**From:** Sue Howell  
**Sent:** 01 July 2019 12:07  
**To:** Planning.Responses <[Planning.Responses@arun.gov.uk](mailto:Planning.Responses@arun.gov.uk)>  
**Cc:** Anita Gardner <[Anita.Gardner@arun.gov.uk](mailto:Anita.Gardner@arun.gov.uk)>  
**Subject:** RE: Please find attached amendment on planning application Ref: LU/59/19/PL

Comment from Greenspace

**APPLICATION** LU/59/19/PL  
**NO:**

**Description of Works:** Installation of 5 No. 'vehicle-to-ground' lifts, HVAC plant units, a canopy cover over the

PR/19 04 02/GA/01 REV A

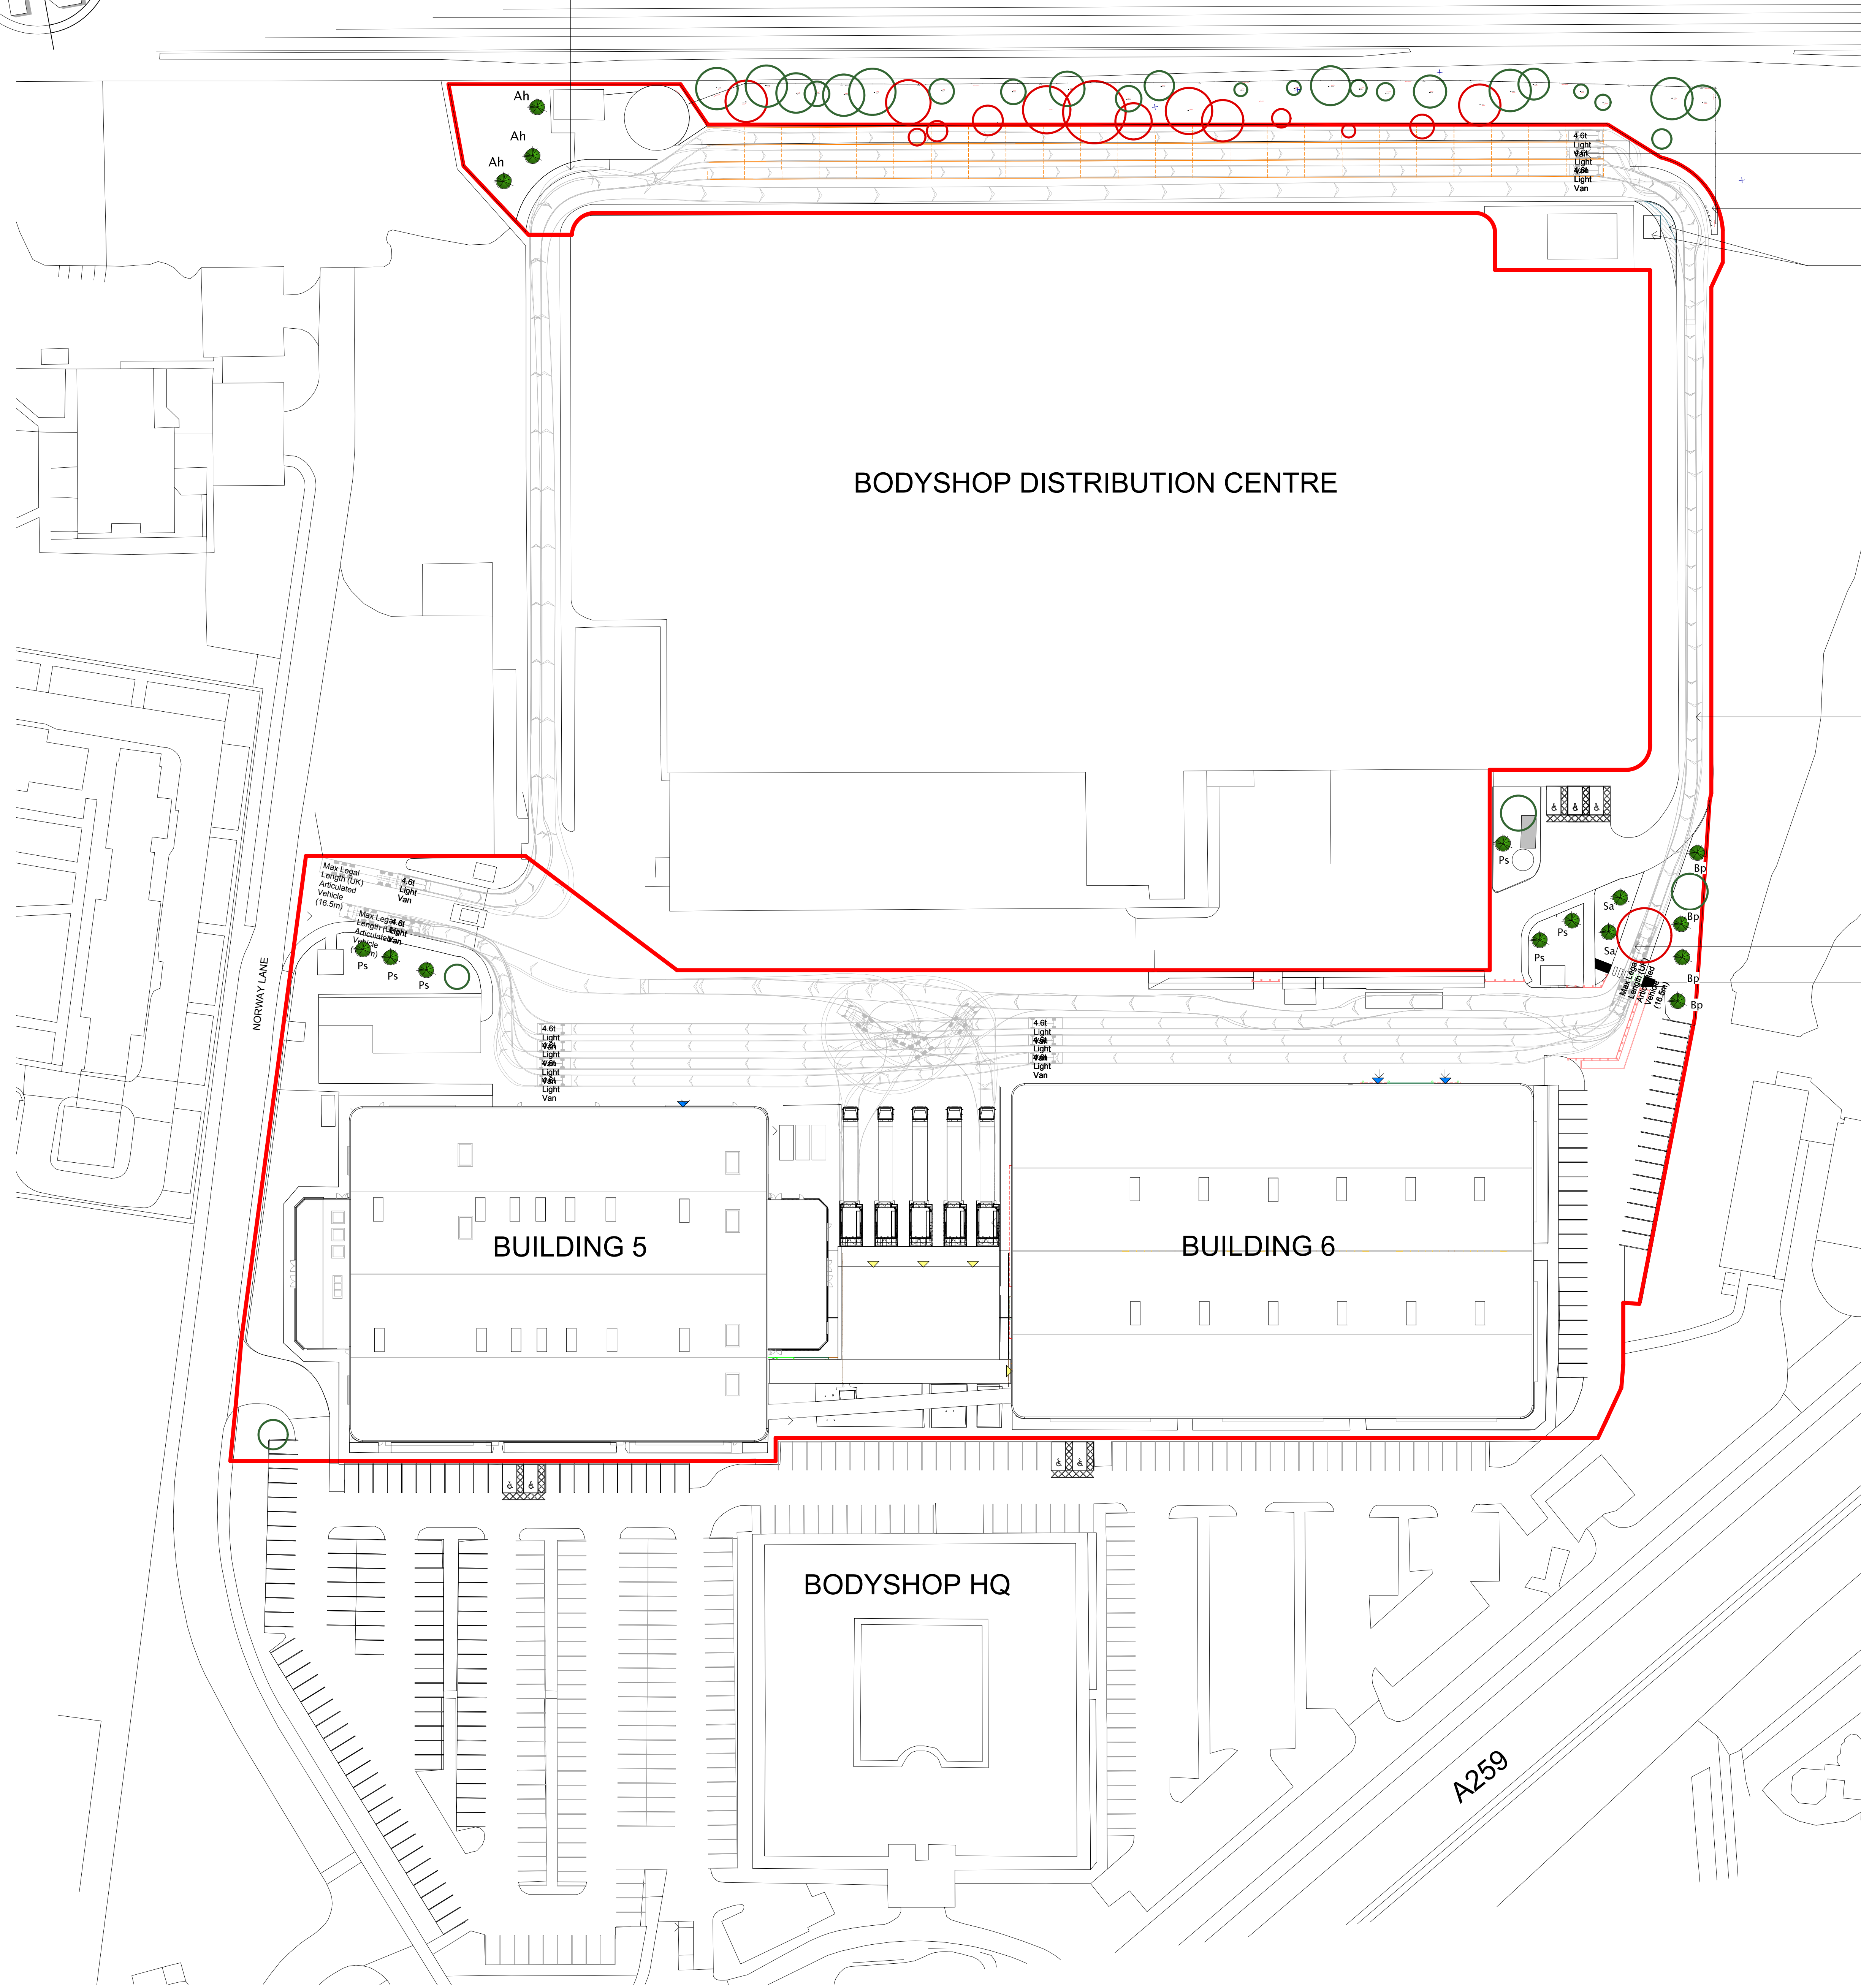
The Landscape detail provided in proposed Tree planting Works GA plan Dwg PR/19 04 02 / GA/01 REV A proposes tree planting which would appear suitable for location and application. The detail has been provided in plan form with species choice, planting density and size at time of planting.

I would have recommend no Landscape objection to the proposals contained within application LU/59/19/PL
